**RE: 6/2023/0444/COND – Land to the North-East of King George V playing fields, Northaw Road East, Hertfordshire, Cuffley, EN6 4RD**

Thank you for consulting us on the above application received on 10 May 2023, for the submission of details pursuant to condition 6 (surface water drainage), on planning permission S6/2015/1342/PP for the residential development of up to 121 dwellings, associated infrastructure, and a change of use from agricultural land to an extension of the King George V playing field.

We **Object** to this applicaiton in the absence of an acceptable supporting information in relation to discharging condition 6, and note that condition 19 is related. An amended flood risk assessment with modelling information has been provided, however, the following issues in relation to condition 6 still stand.

**Figure 3-1 Updated direct rainfall area.**

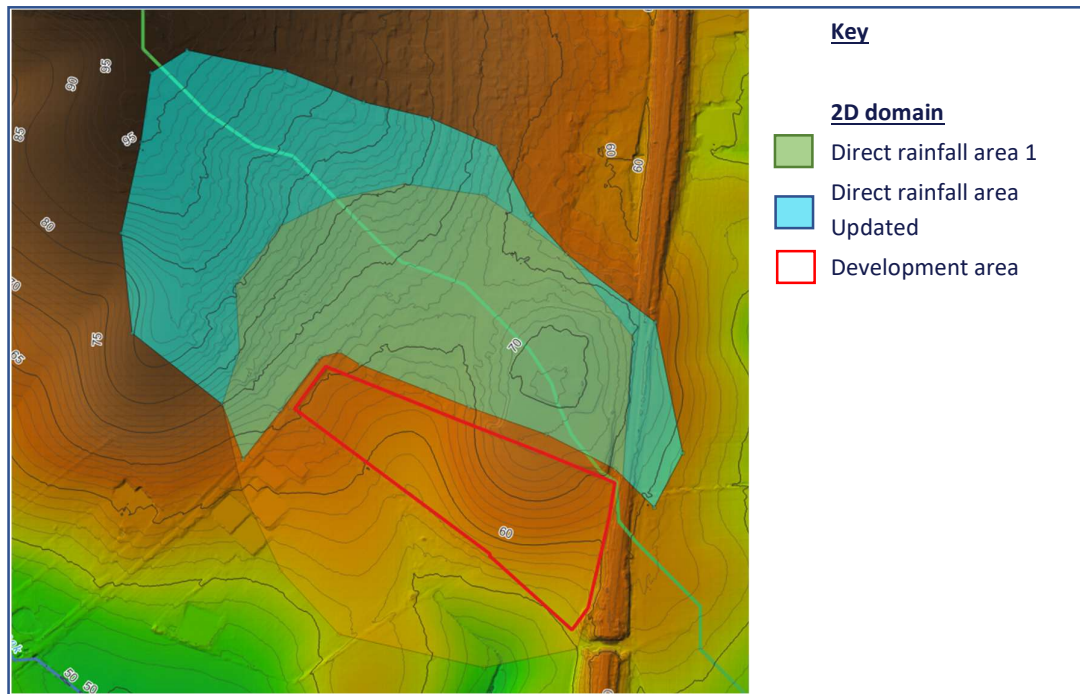
- The rainfall catchment (polygon) for direct rainfall needs to be extended, as it does not provide an accurate representation of the full drainage catchment.

Figure 4-1 Railway underpass

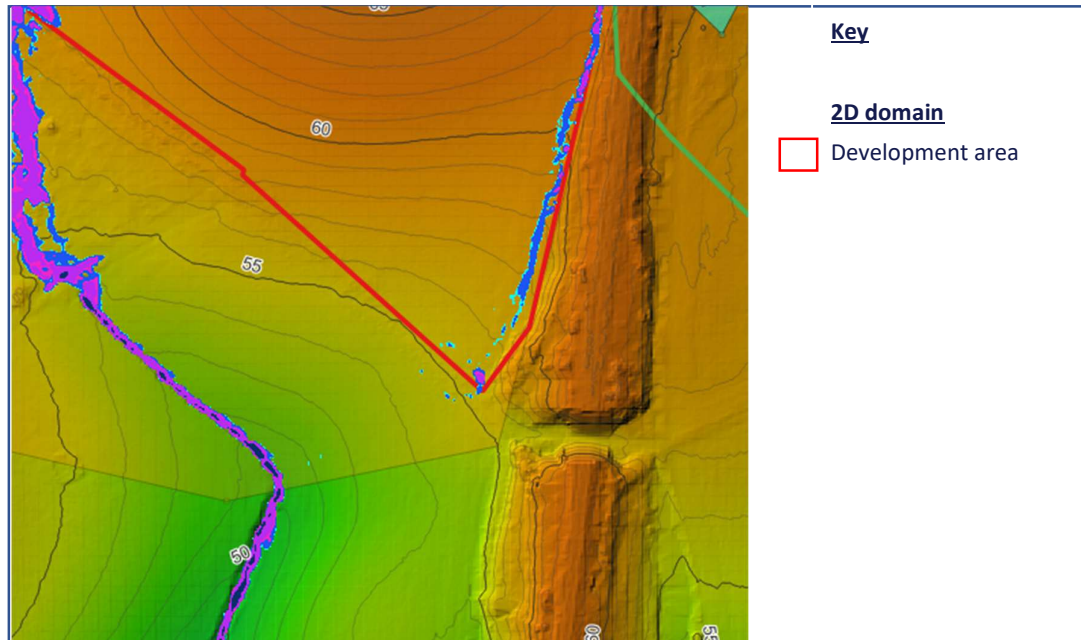
- Confirmation as to whether the railway underpass at the south-east extent of the site has been modelled, as this could potentially alter flow paths or downstream boundary.

**Figure 4-2** Maximum flood depth Surface water, 1h duration 1 in 1000yr

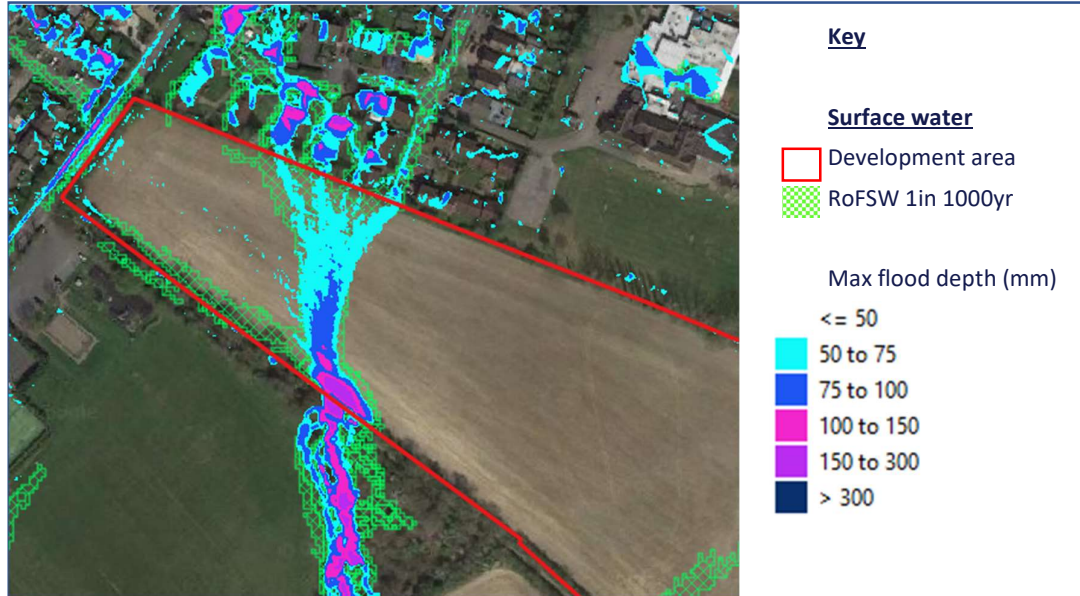
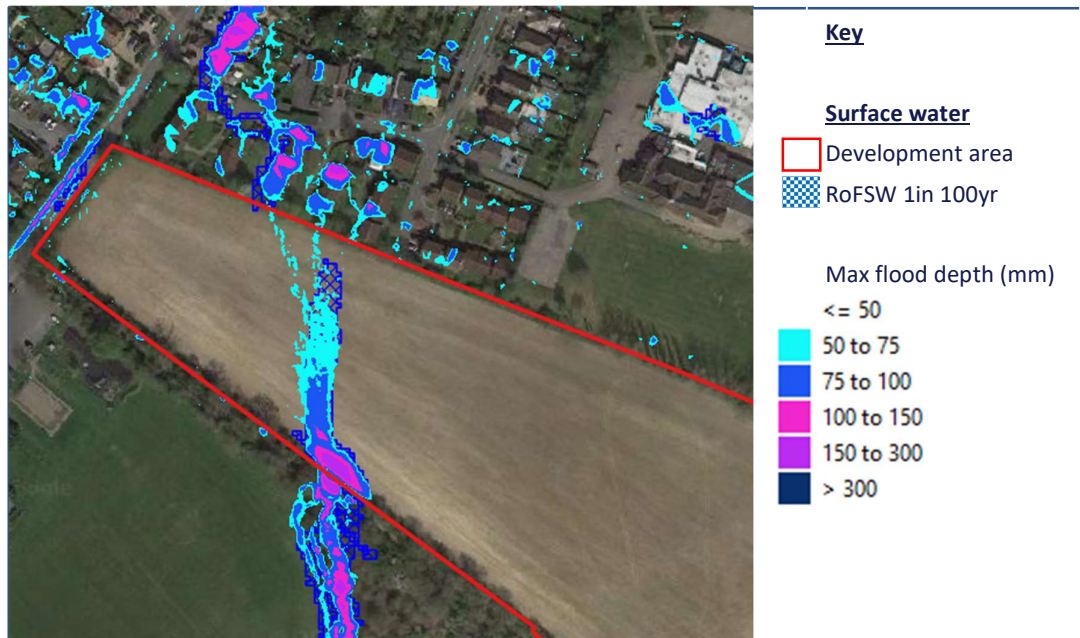
- Provide a comparison of EA surface water maps alongside the surface water model baseline scenario. Surface water flooding depth difference maps between pre and post development should be provided to illustrate comparisons to help verify results and identify where flood risk is reduced or increased. Appropriate key with labels should be included.
